From: Amanda Scholes on behalf of Planning.Responses
Sent: 18 July 2018 09:59
To: Planning Scanning
Subject: FW: Hares Dihatsu, Rustington

From: Laura Gibbons
Sent: 17 July 2018 13:57
To: 'Chris Hendry'
Cc: Ziyad Thomas; Anita Gardner
Subject: RE: Hares Dihatsu, Rustington

Hi Chris,

Scale: 1:125	Paper Size: A1	Date: JUNE 2017	Drawn By: JH	Checked By: CH
Project No. RRL012	Drawing No. 505	Revision: P4

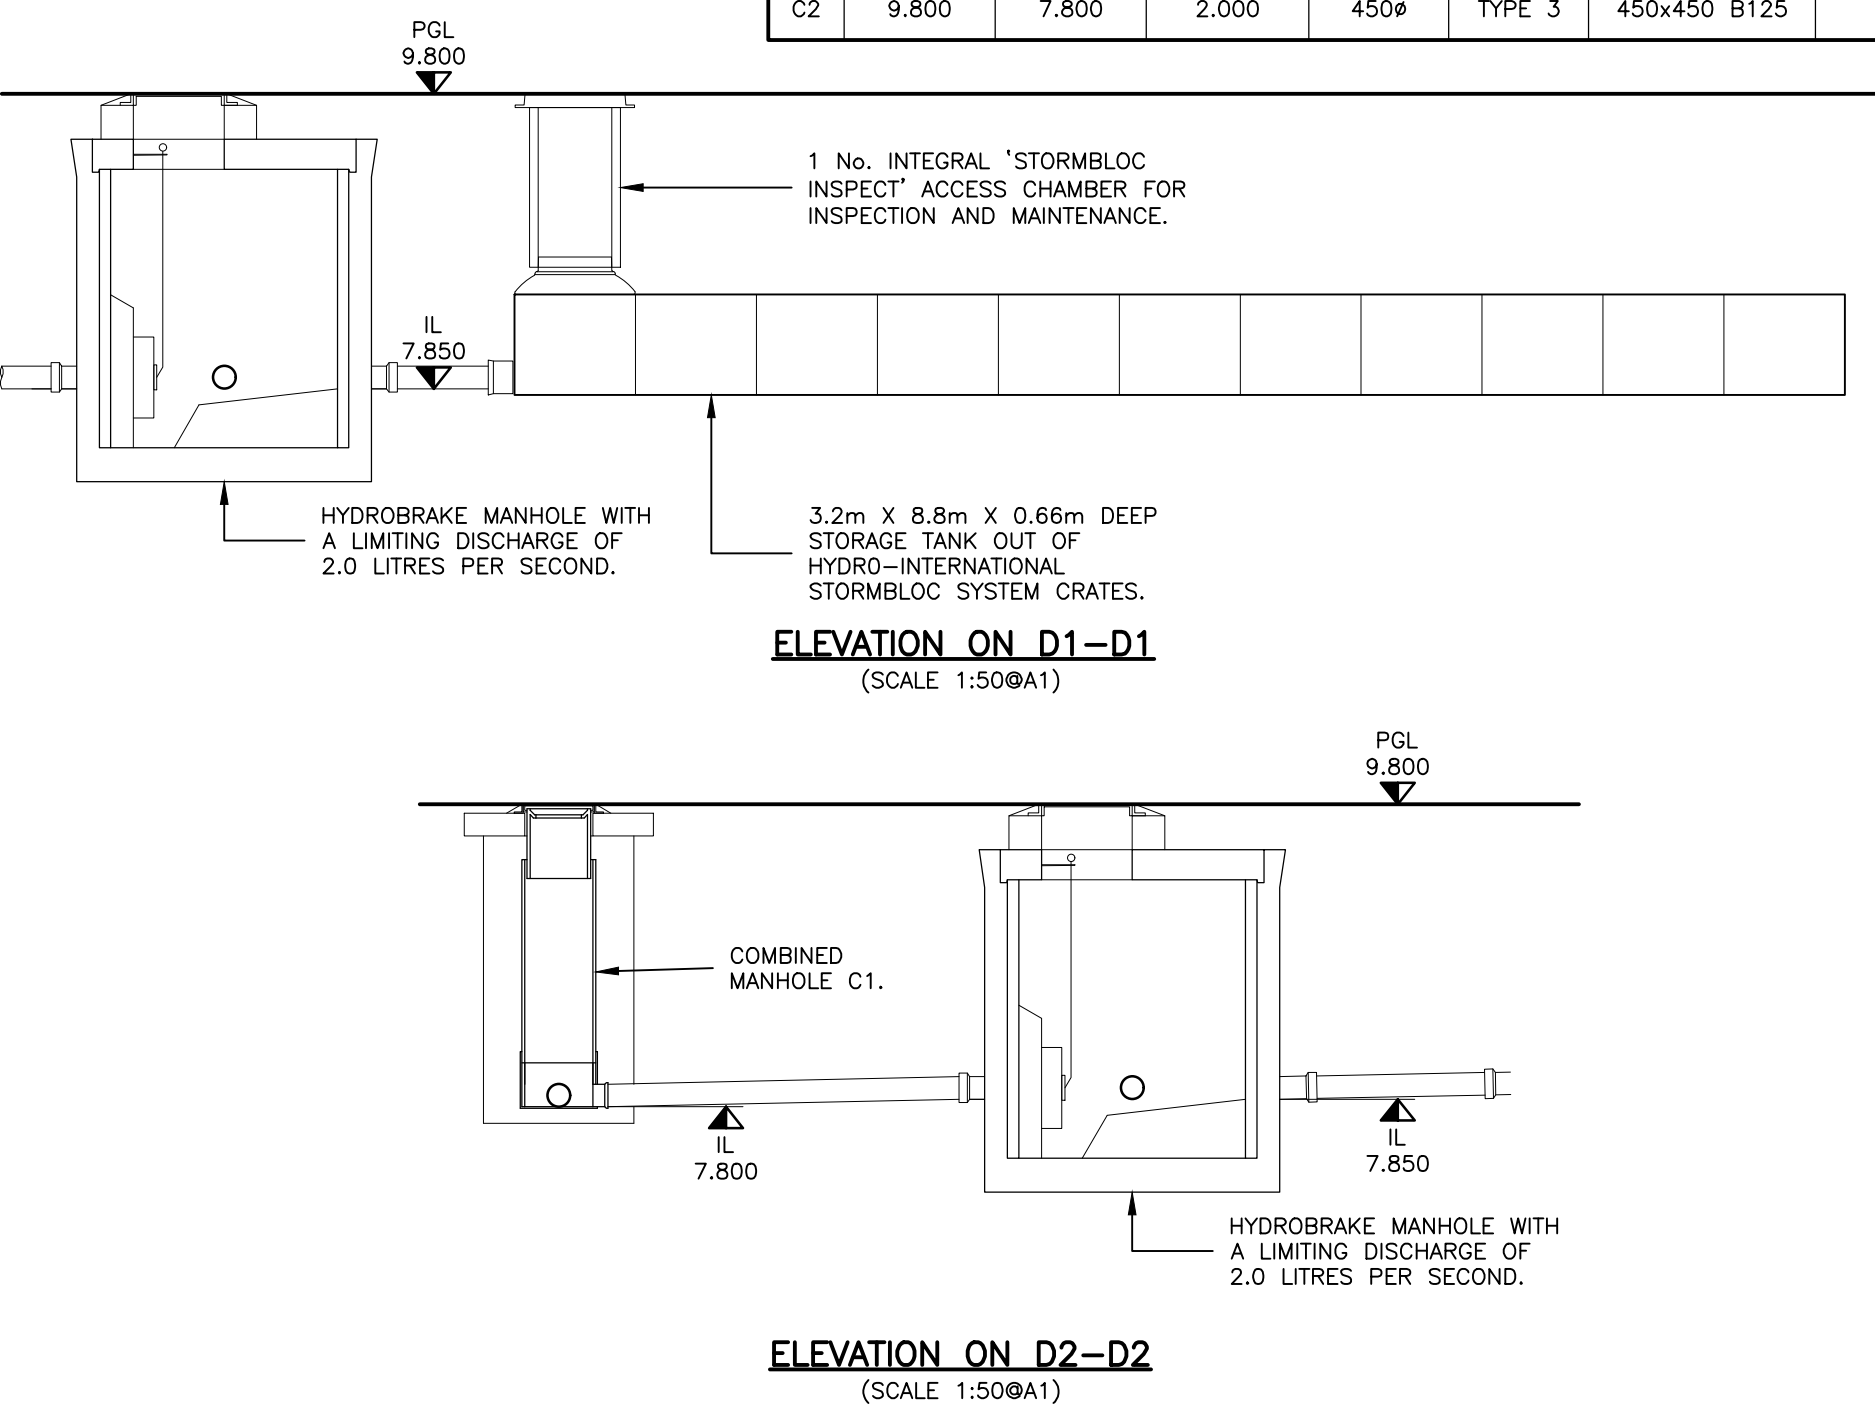
You are also planning on discharging to a foul sewer. Which is what I want to remove, in line with Building Regulations and CIRIA I would like you to follow the hierarchy for surface water drainage disposal. You have not done this, and infiltration testing is required to show if it is possible to infiltrate more surface water. I asked if there were neighbouring sites to try to remove the need for this further testing. However, no sites are in true close proximity to the site.

Hi Chris,
The site you mention is quite a distance from your site.
We really need to see winter groundwater monitoring for your site, as detailed in the condition.
At what depth were the percolation tests conducted at?
Thanks,

The condition specifically states the requirement for these results to be supplied.

Percolation test results are required to prove the viability (or not as the case may be) of infiltration.

Winter groundwater monitoring is required when infiltration is to be used to ensure sufficient capacity is provided above the maximum winter groundwater level.
